Our ref: HMS ID 13831

Advice on Environmental Impact Statement – State Significant Development

Proposal: Mixed use development with infill affordable housing - 160 Oxford Street, Paddington

Major Project reference: SSD-97528708

Figure 4.5
Overshadowing diagram showing the impact at 9am on 21 June
Source: Smart Design Studio

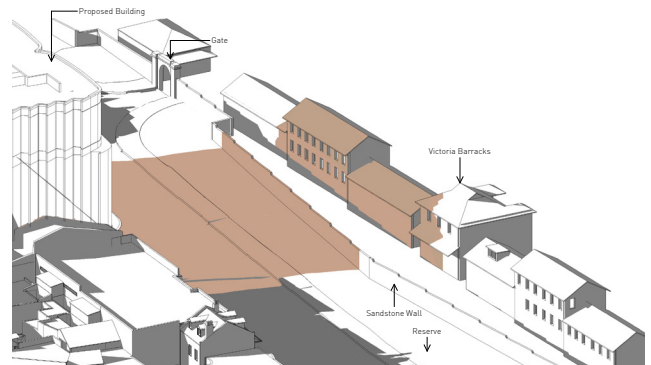
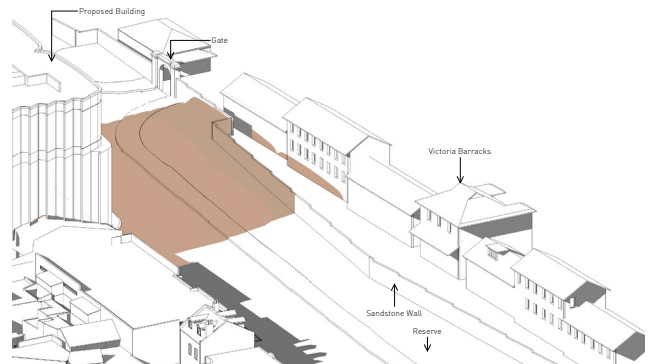
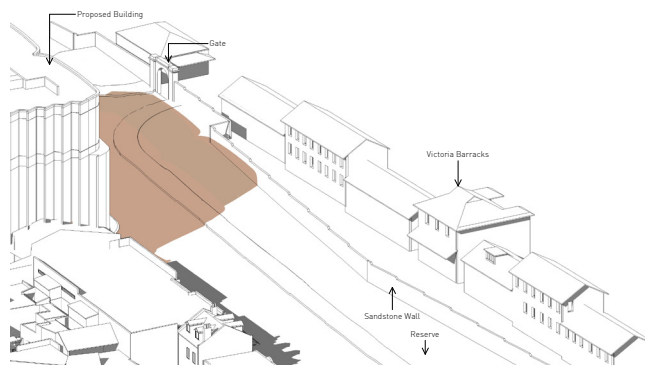
1. The SoHI notes that there will be partial overshadowing of Victoria Barracks Buildings 95 and 96 in mid-winter. We request that the proponent provide additional information on the significance of these buildings and assess how the overshadowing would impact their significance.

Figure 4.9
View to the proposed building around 200 metres from position 1, outside the front of B1, looking across the Barracks Square
Source: Virtual Ideas

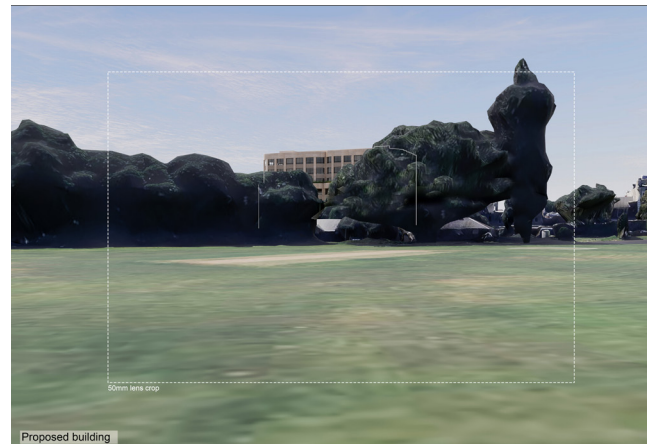
3. We request accurate view analyses be provided from key viewpoints within Victoria Barracks. The Visual Analysis does not include any views from within Victoria Barracks and the digitally modelled view analysis provided in the self-assessment report is limited in its effectiveness. We note that the proponent was not been able to access Victoria Barracks and recommend that further efforts are made. Heritage NSW may be able to provide assistance to facilitate access if requested.
